RE: Resubmission of SDD 8588 (Mod 3) - Eastern Creek Business Hub Stage 1

Ethos Urban has prepared this letter on behalf of Frasers Property Australia in response to your letter dated 27 September 2019 requesting additional information prior to acceptance of the modification application. **Table 1** below outlines our response to each of the matters raised. The proposed modifications to the conditions of consent are provided below the table.

drawing title
PROPOSED ROOF PLAN -
STAGE 1

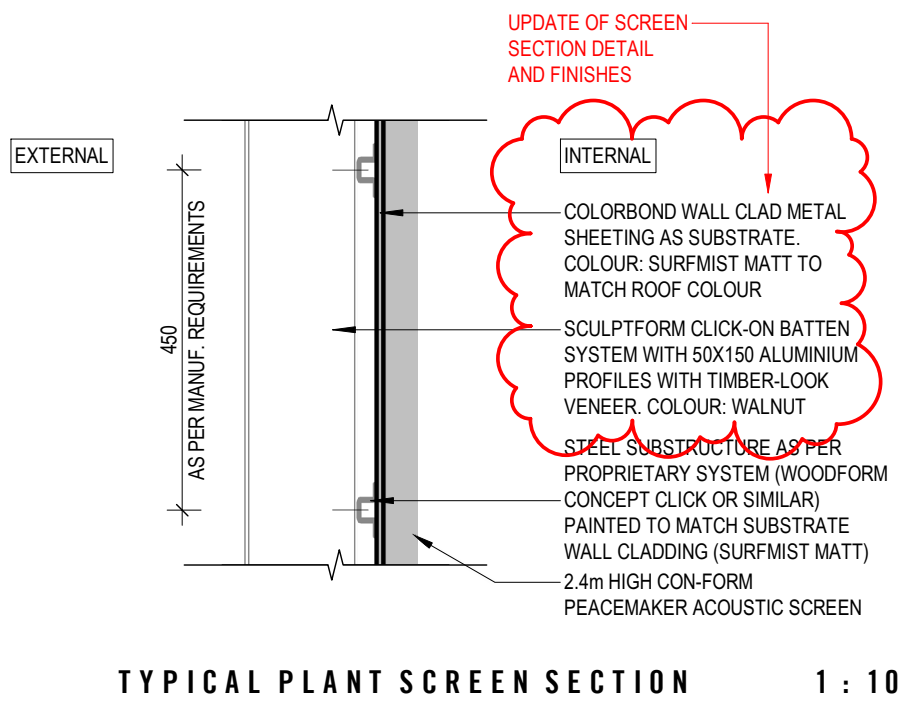
Issue	Response
<p>1. Screening around plant room/ condenser Clarify any changes to acoustic screening in addition to the screen material changes proposed. It is noted the typical plant screen section on the approved roof plan stage 1, DA06, issue B, shows a 2.4m high acoustic screen however on the proposed roof plan, DA06, issue P1, the acoustic screen is not shown.</p>	<p>The acoustic screen is identified in the amended roof plan. It includes the newly proposed materiality along with the 2.4m high acoustic screen.</p>
<p>Identify the location of the screening on the roof plan.</p>	
<p>2. Shade Sails Provide advice from a landscape designer, confirming the void between the shade sails is sufficient for tree growth and the proposed Spotted Gum trees can be successfully accommodated with the proposed shade sails.</p>	<p>Advice has been provided by Arcadia Landscape Architecture making this confirmation.</p>
